From: Egan, Clare [REDACTED]
Sent: 13 September 2017 12:12
To: Anita Gardner
Subject: RE: *EXTERNAL: LU/211/17/DOC Courtwick Lane, Littlehampton

Subject: *EXTERNAL: LU/211/17/DOC Courtwick Lane, Littlehampton

The Council's Landscape officer has made has made the following comment today in relation to condition 4

Planting Plan

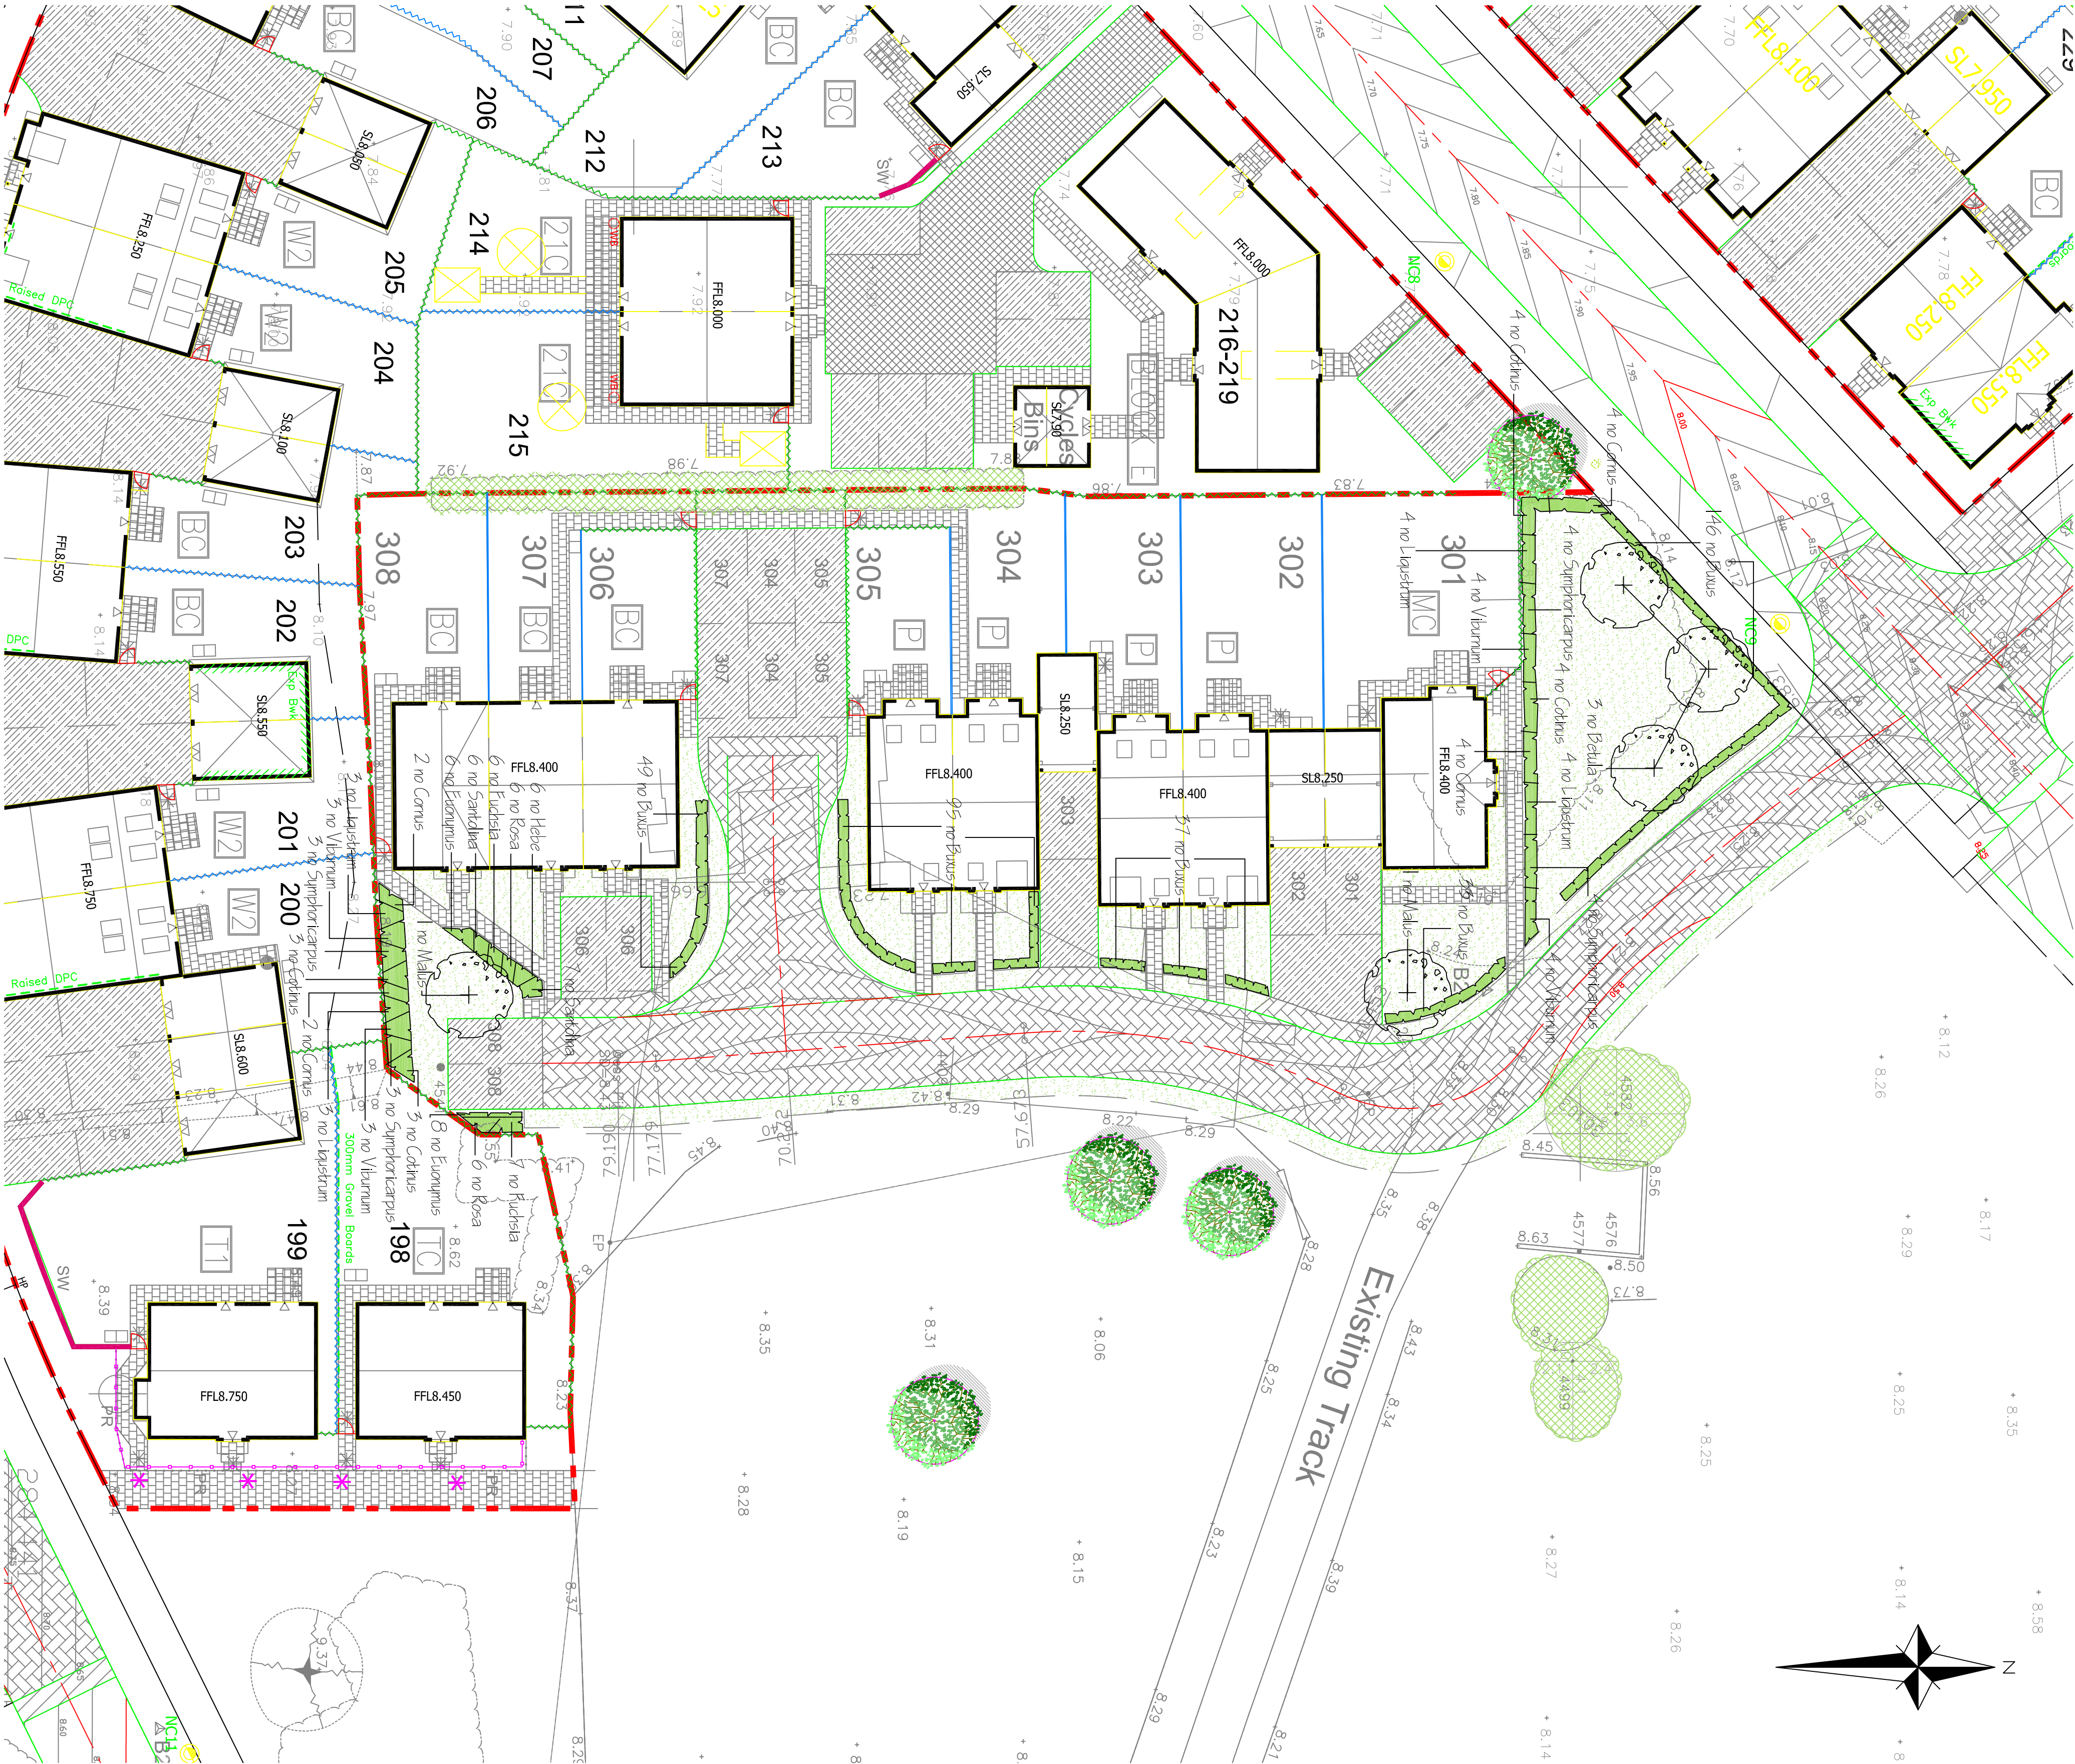
Drawings submitted under application LU/211/17/DOC Dwg 1120/01 March 2017 provide a well thought out scheme which is suitable for location with good detail of species choice in plan form being proposed, however these drawings need to detail actual numbers being proposed for each species in these locations rather than just stating a block mix of dwarf shrub and screen mix. We would request that this information is submitted for approval therefore we would not recommend the discharge of Condition 4 landscaping on application LU/211/17/DOC imposed under LU/24/17/PL until this additional information is submitted and approved.

Please find attached an updated landscape plan, rev B, for Courtwick Cottages -- the plan now shows the actual numbers of plans rather than just percentages.
